Department of Transportation

Region 2 Permits

October 25, 2024

RE: Waterbury Filing No. 1
Final Plat (SF237)

POND 3
SCALE: 1"=30'

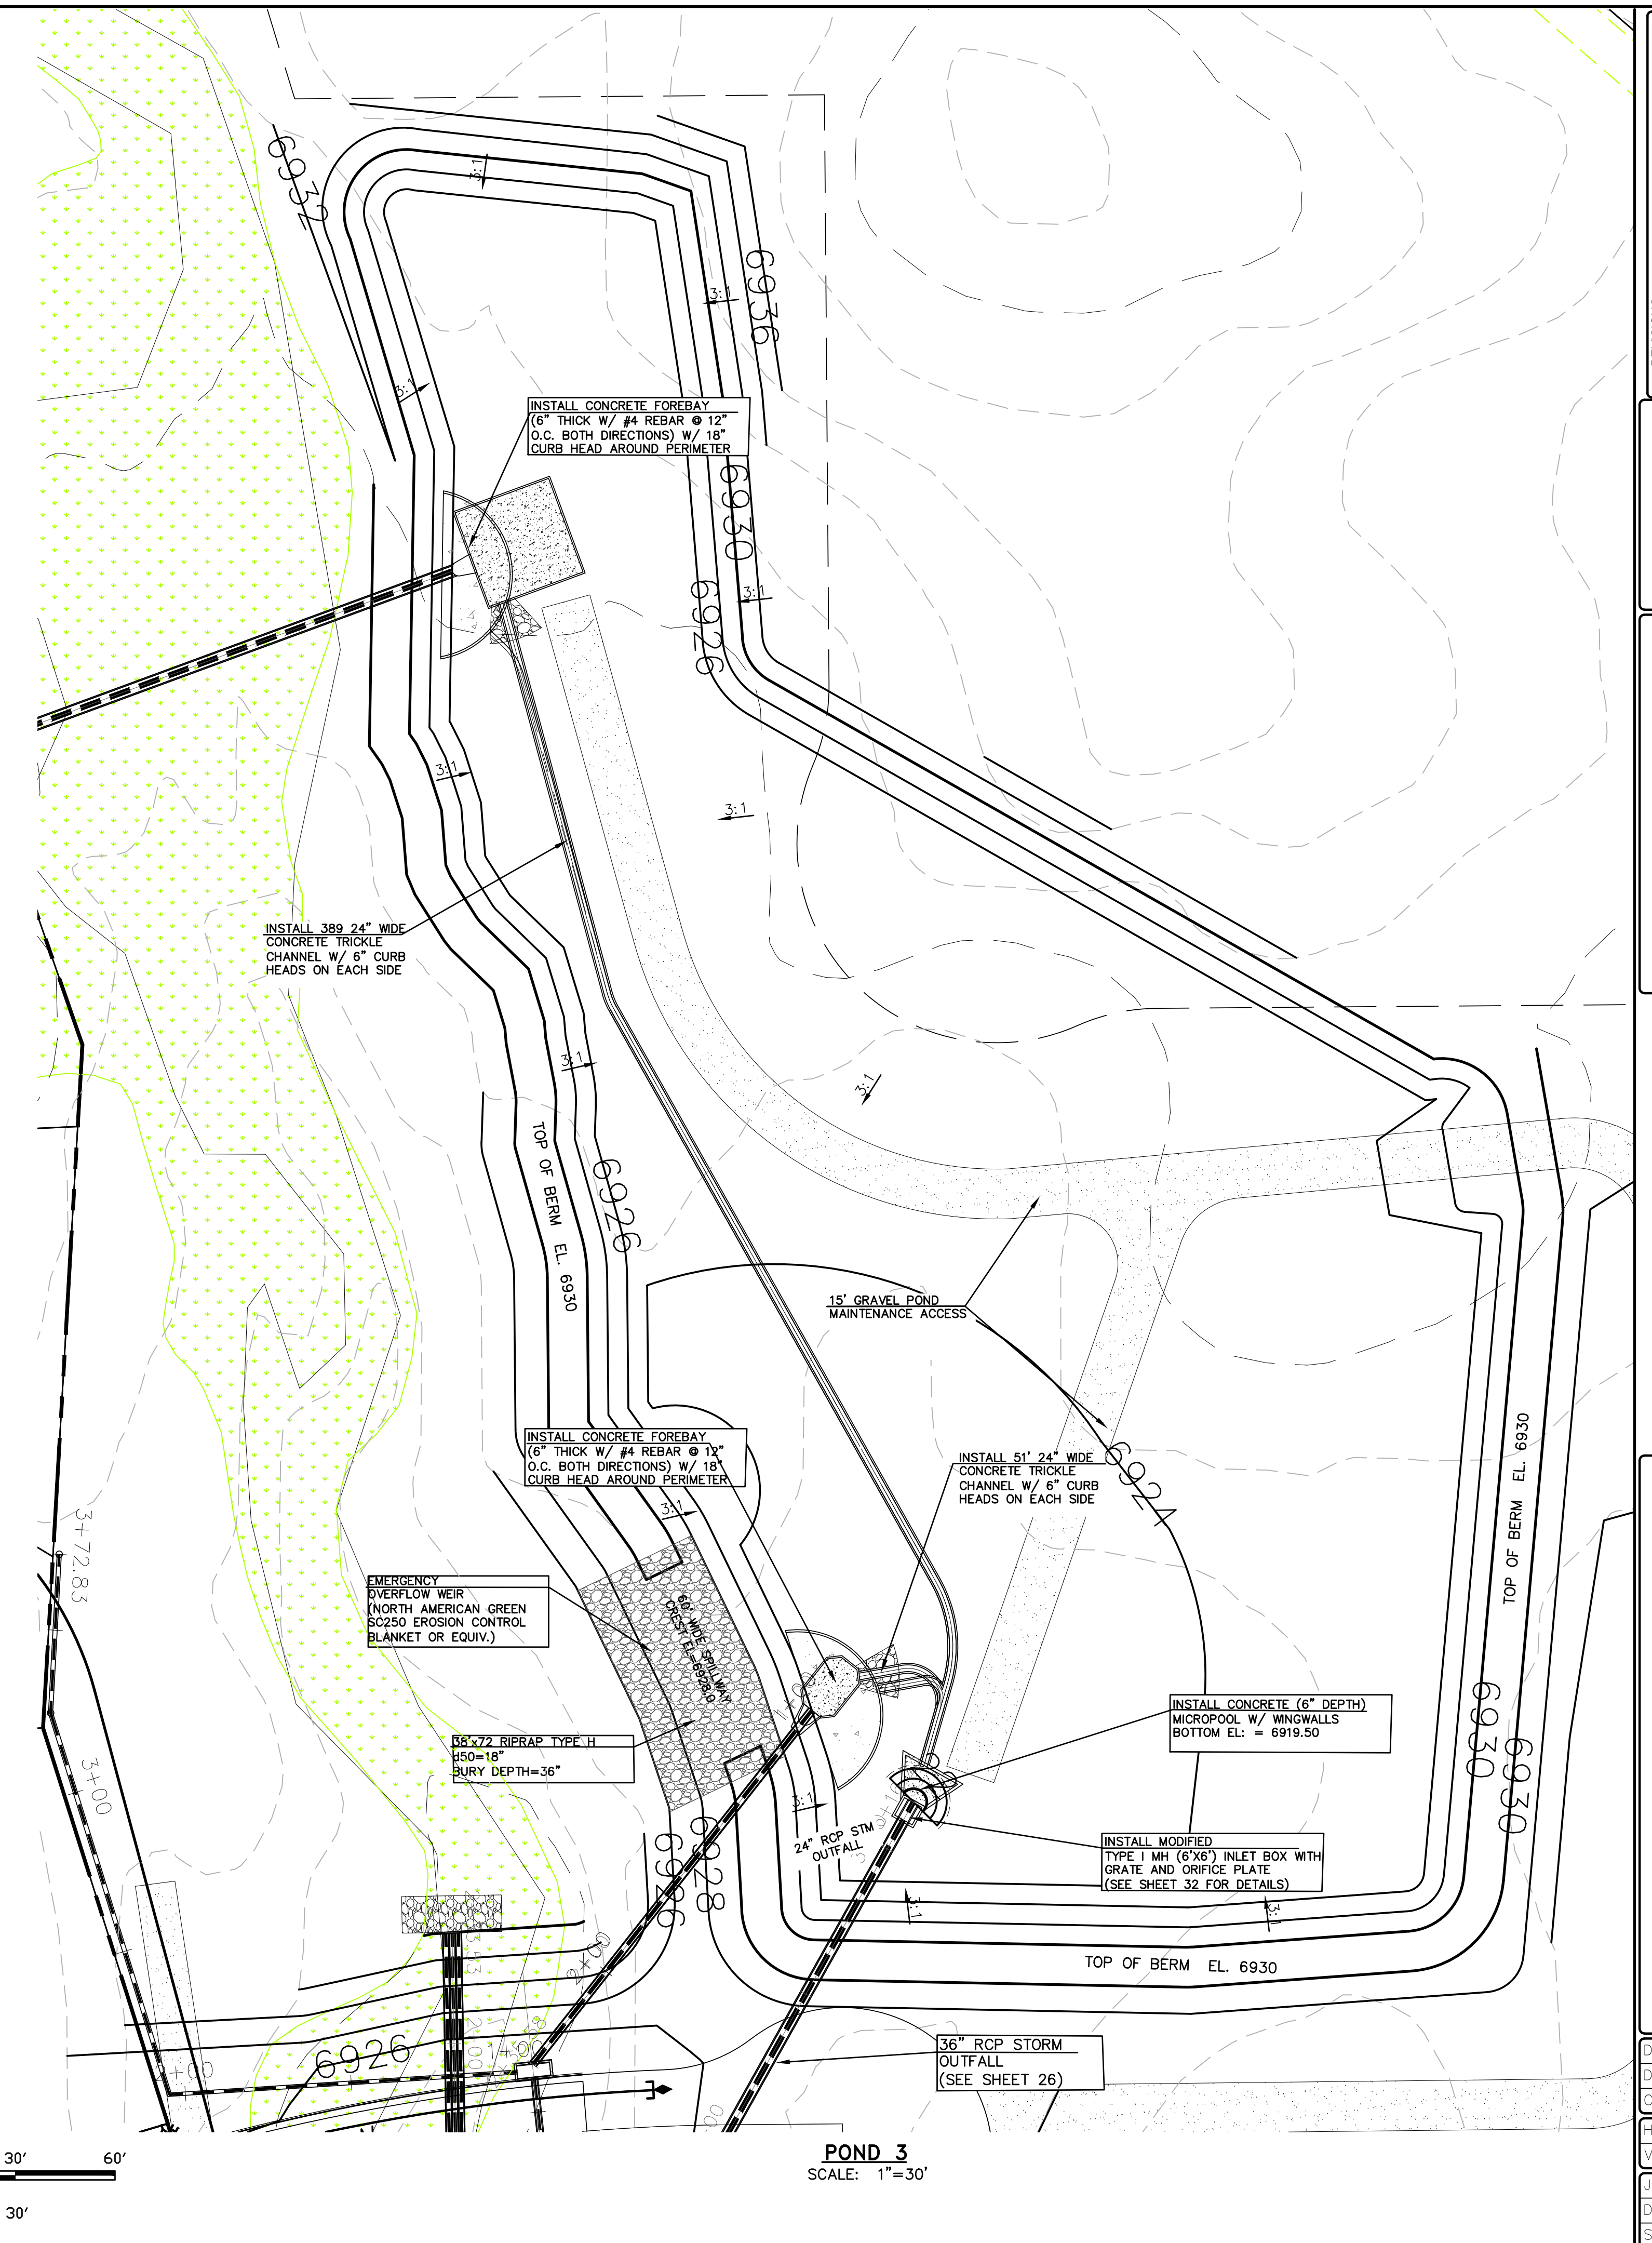
- Sheet No. 48 - the spillway for Pond 3 is shown to have 3:1 side slopes and 1 foot of freeboard. The drainage report (pdf p. 237) shows the spillway as having 4:1 side slopes.
 - Revise the plan or report to provide consistency.

REVISED TO
4:1, 8'
